Julia Finn MP Member for Granville

Application SSI-22765520

Thank you for the opportunity to provide this submission concerning as proposed in the “Rail infrastructure, stations, precincts and operations – Westmead to Sydney CBD Environmental Impact Statement – March 2022.”

Westmead station

Figure 7-1 Indicative layout and key design elements – Westmead metro station

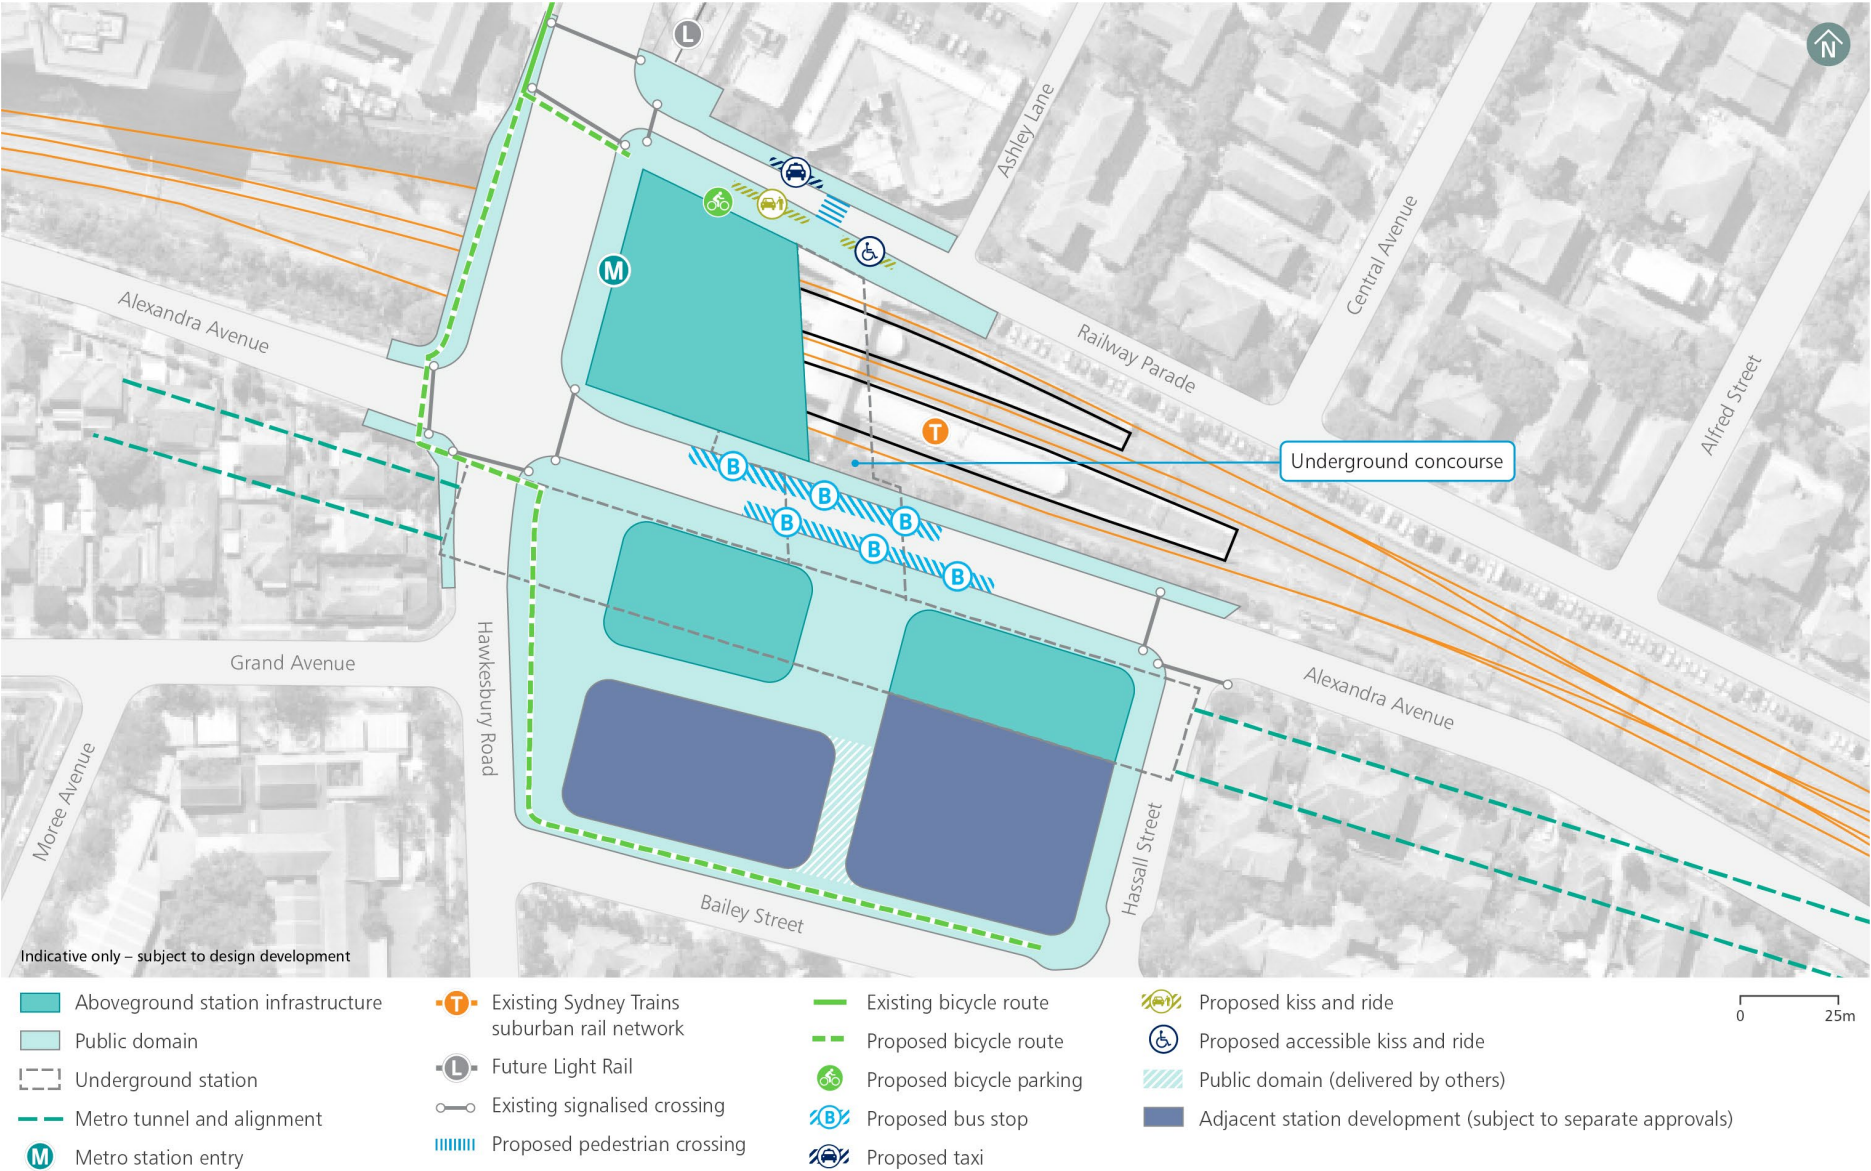
Despite two entrances being marked on the indicative cross section of the proposed Westmead station, the text indicates “*Entrance on Hawkesbury Road. Sydney Metro is continuing to investigate the opportunity for an additional southern station entrance.*”

The proposed design of the majority of other metro stations within the EIS includes at least two entrances at each site.

Given the location of the Westmead metro station it is not clear why the current proposal includes only one entrance.

It does not make sense to channel significant foot traffic from the surrounding area and from the light rail and bus transport hubs into a single entrance. The designs of other proposed stations contained within the EIS acknowledge the need for more than one access point and it is not clear why Westmead station should be treated any differently.

With a single entry to the entire station complex local residents will have to walk much further to access trains. It is also less safe in the event of a the single entrance needing to be closed.

In addition, Hawkesbury Road is a major thoroughfare to Westmead Hospital. Emergency vehicles regularly use the road on the way to and from the hospital. With a congested single entrance onto Hawkesbury Road, it could be dangerous to have everyone crossing at a single location there is a risk that emergency vehicles could be delayed.

Accordingly, I encourage Sydney Metro to "investigate the opportunity for an additional southern station entrance," and furthermore to ensure the second entrance in the design of the station.
